COUNTY COUNCIL'S RESPONSE TO CONSULTATION ON THE FOLLOWING DEVELOPMENT PROPOSAL

Application No: 19/01705/OUT

Proposal: Outline planning application for the erection of up to 95 dwellings with public open space, landscaping and sustainable drainage system (SuDS) and vehicular access point from South Newington Road. All matters reserved except for means of access.

Response date: 7th October 2019

DESIGN INFORMATION	
Design stage	Feasibility
Description of Highway Infrastructure	Simple priority T junction
Checking Authority	County Council / Unitary Authority
Design Codes	MFS & LTN 1/07
Description of Ground Conditions	Not known at this stage

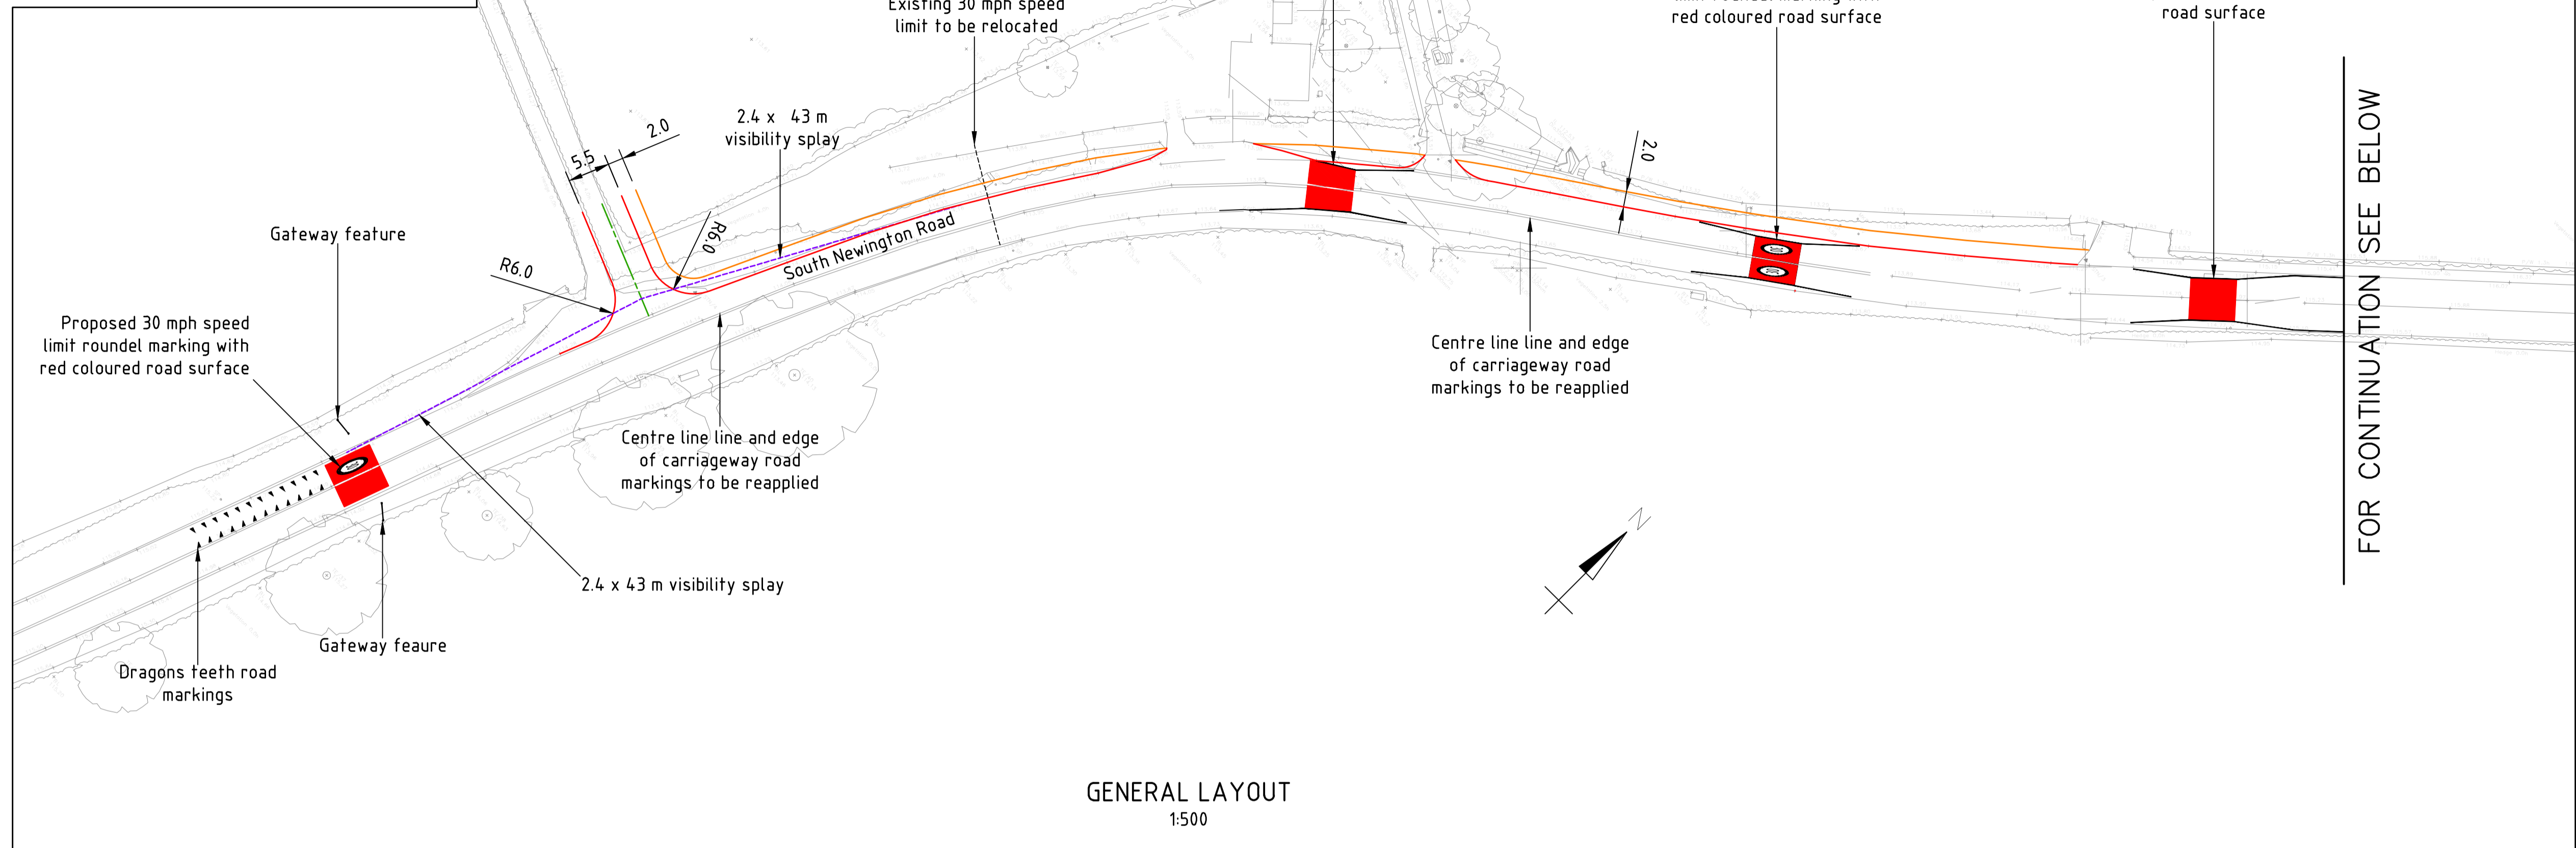
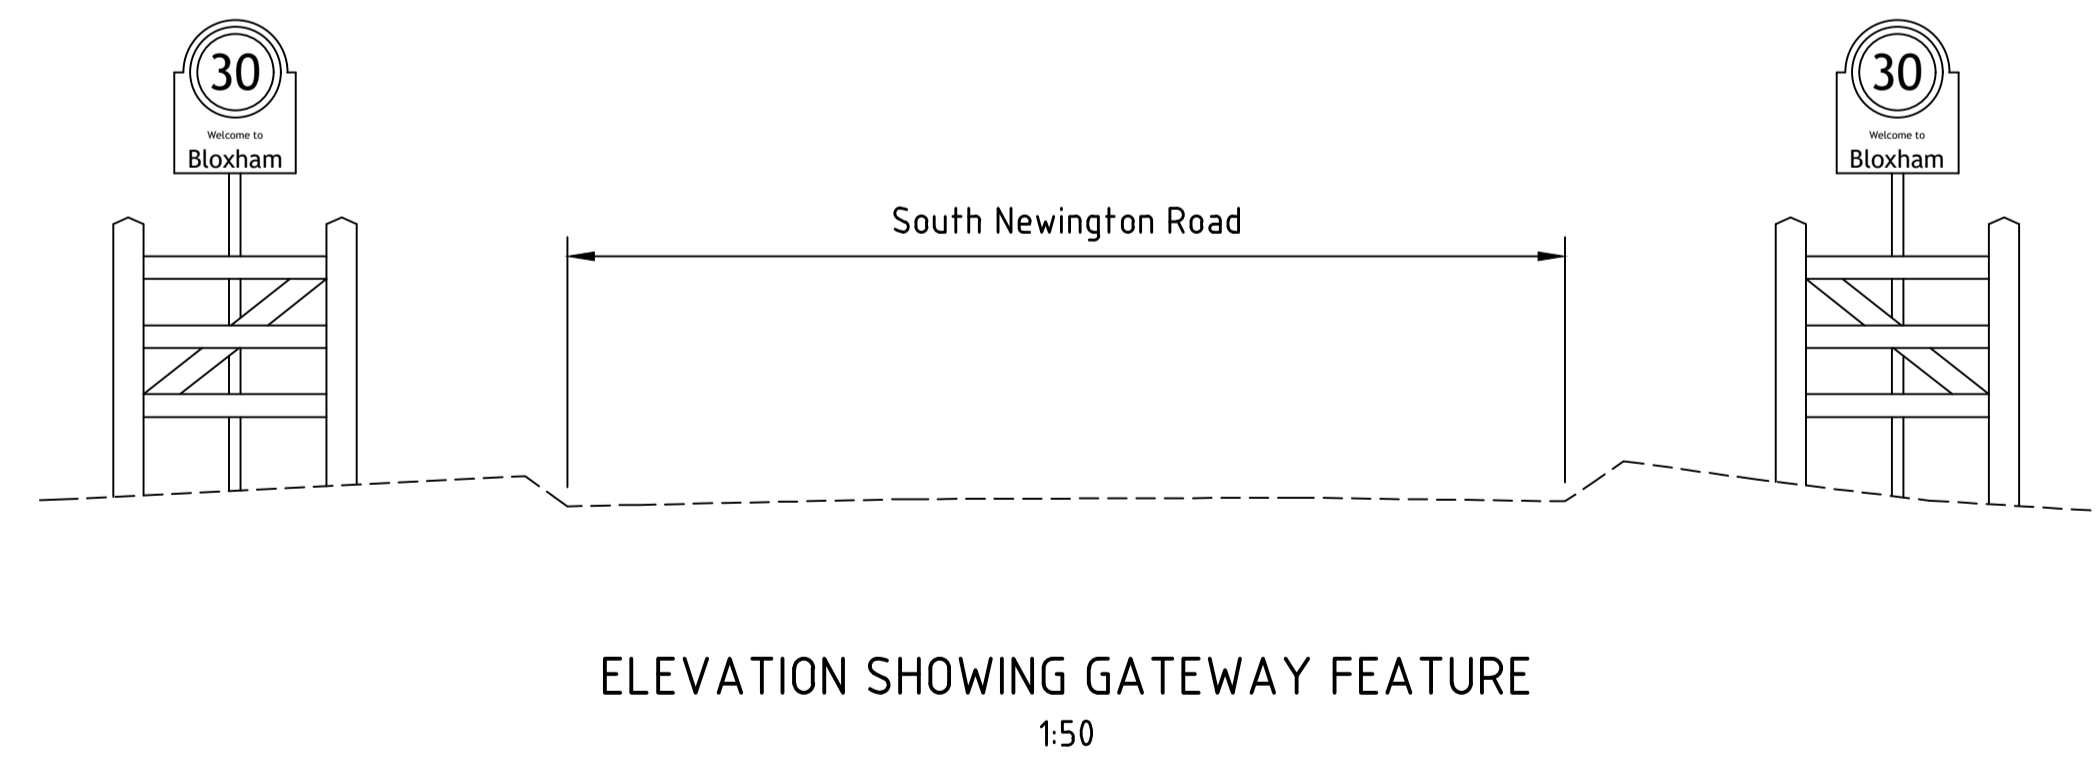
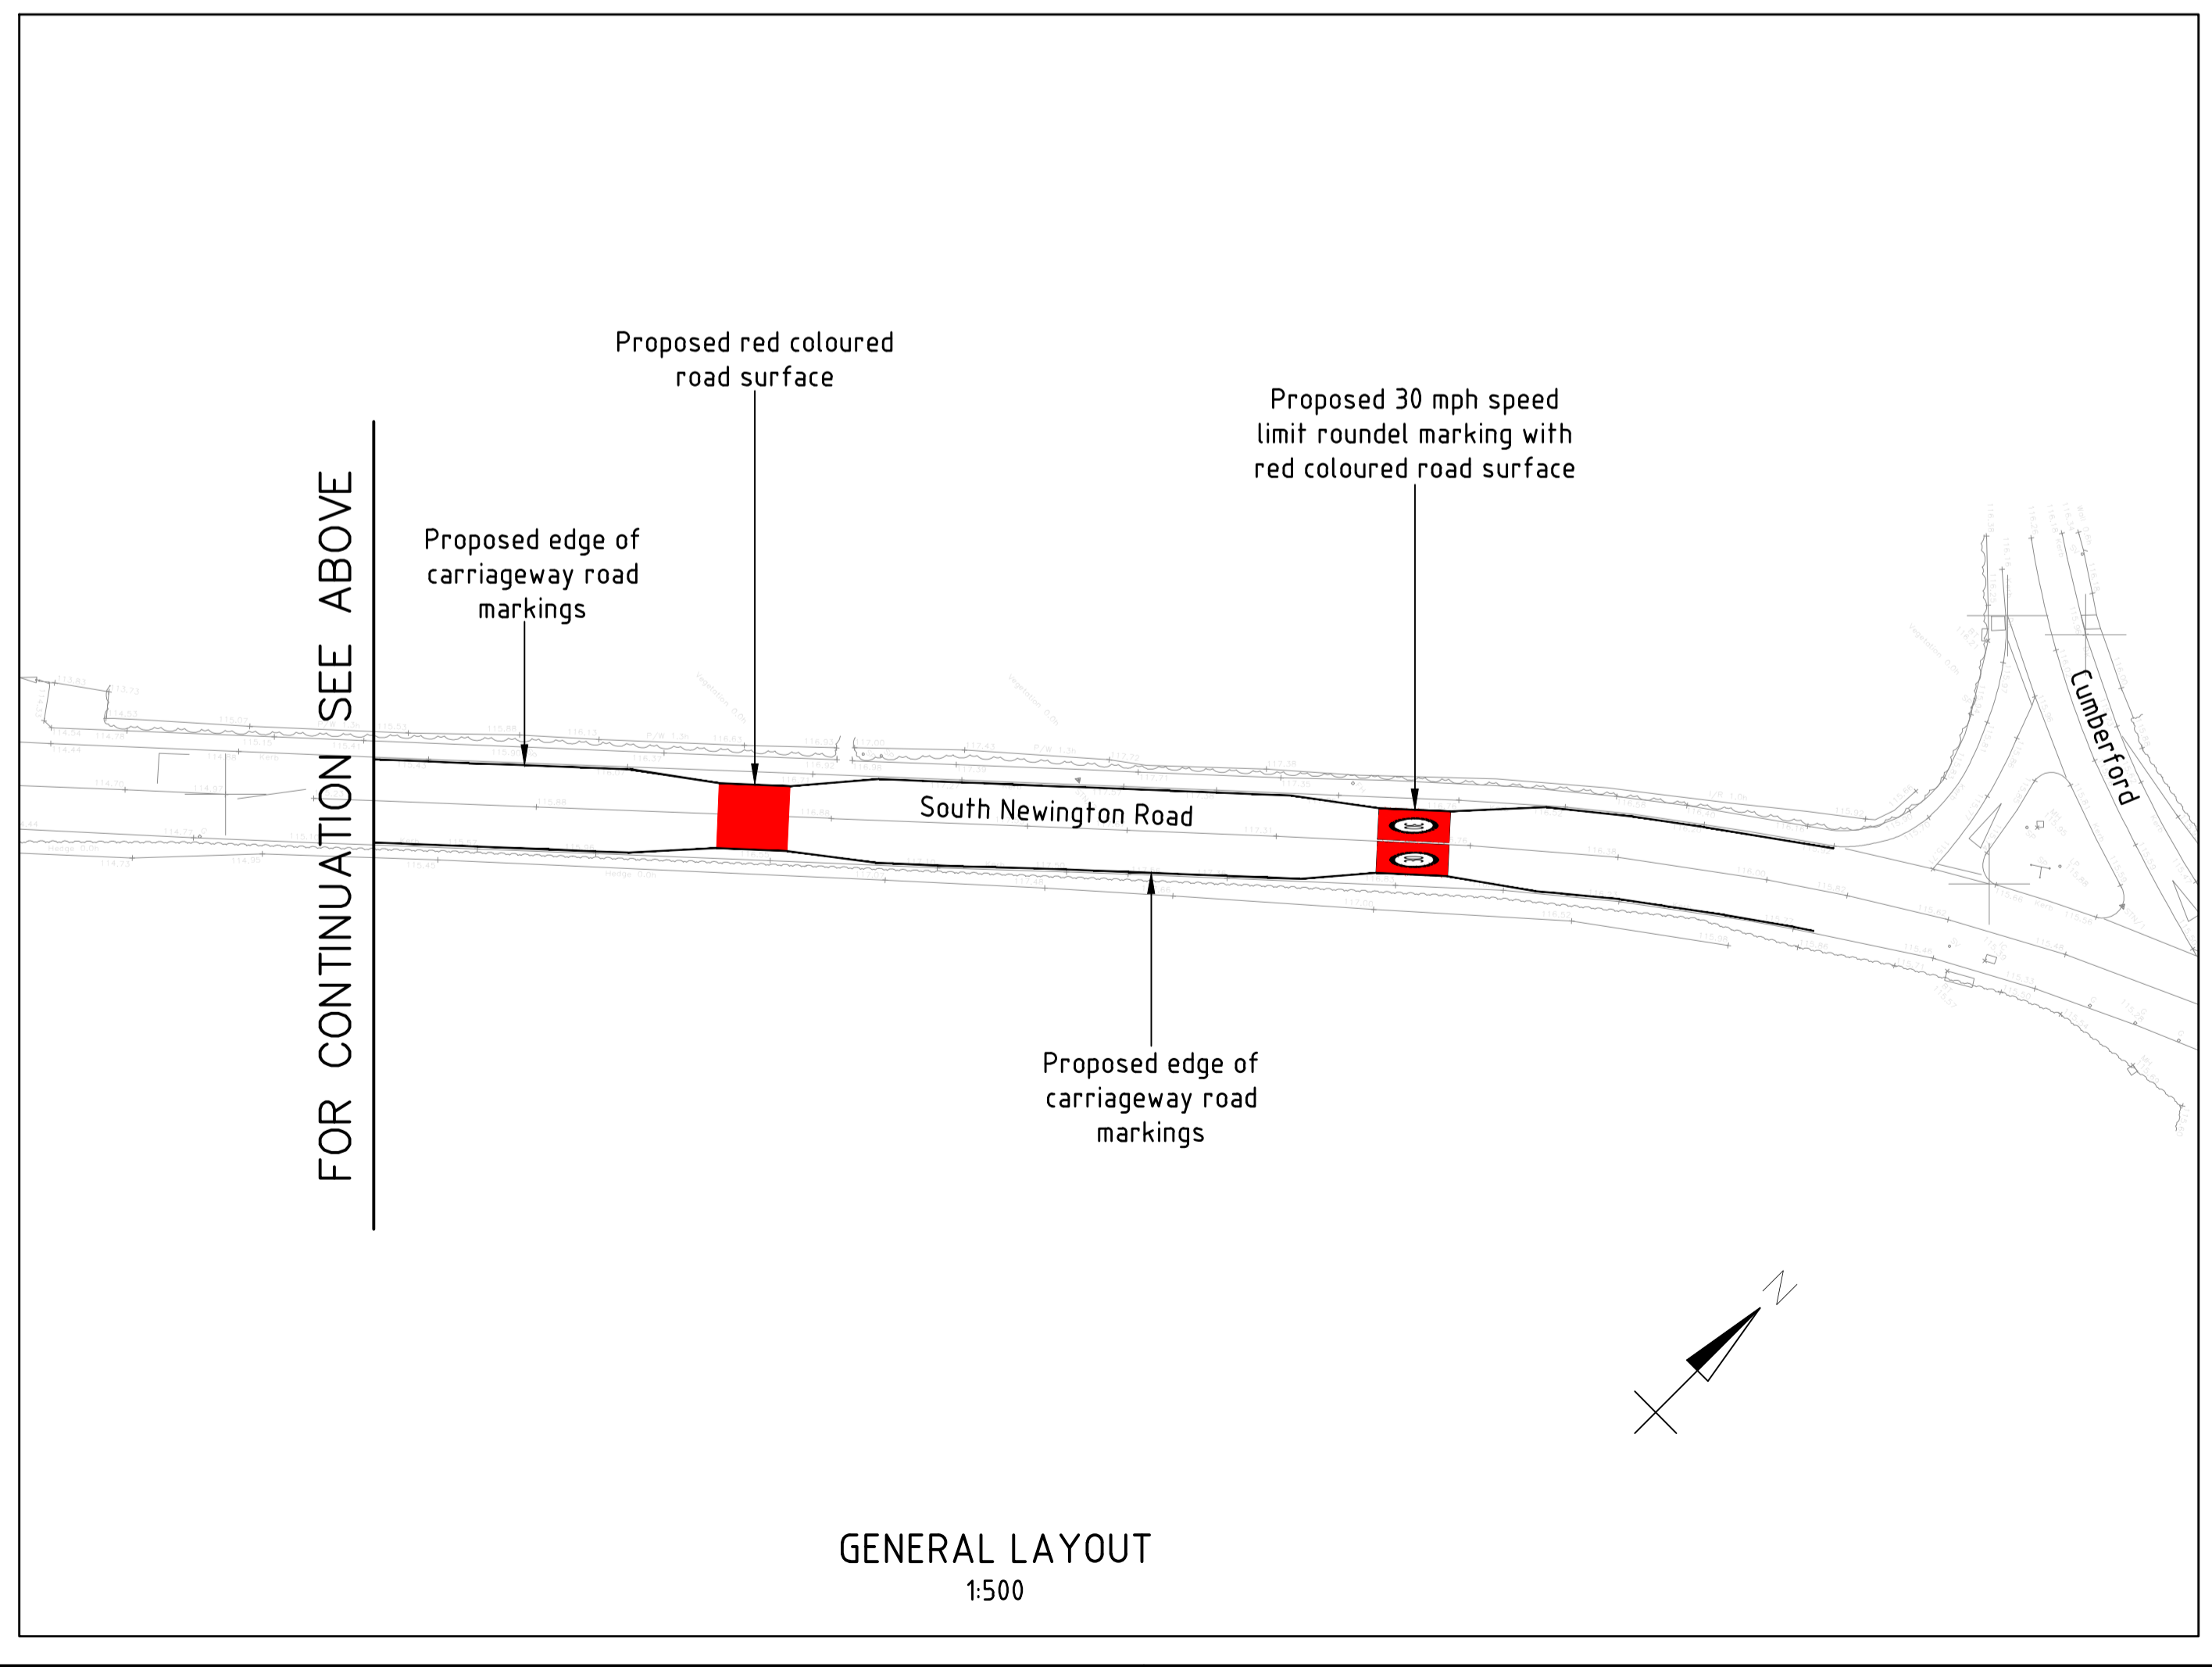
The visibility splays shown in the access plan (4995-00-02 A) are insufficient for the access in this location. These visibility splays measure 2.4m x 43m which meets the standards set out in Manual for Streets for urban environments where speeds do not exceed 30mph. This standard is not applicable in this more rural location with access taken from what is currently an unrestricted section of a classified 'A' road.

The required visibility splay must be based on standards set out in the Design Manual for Roads and Bridges (DMRB) and must be based on 85th percentile speeds at the location of the site access. The TA does not indicate that a speed survey has been undertaken and this is required to determine the required visibility splay dimensions. It must also be demonstrated that the required visibility splay can be achieved taking account of any variation in the vertical alignment of the road.

The visibility splays set out in the application are inadequate and the county council is concerned that, due to the alignment of the road in this location, visibility splays that meet the standards set out in the DMRB do not appear to be achievable. This is an absolute requirement and therefore the county council must object to the application due to the significant impact that access in this location could have on highway safety.

and a 30mph speed limit roundel marking with red coloured road surfacing just west of the site access. Further red surfacing and roundel markings are proposed to the east of the site access. This is unlikely to significantly alter speeds of vehicles approaching from the west as they pass the site access. Furthermore, the red coloured road surface markings are not permitted by OCC.

Vehicle tracking is required at the site access junction to demonstrate that the largest vehicles expected to require access to the site can safely and easily access and egress the site from all directions whilst passing another vehicle at the access junction. This must include tracking for a fire tender and refuse vehicle with the dimensions outlined below:
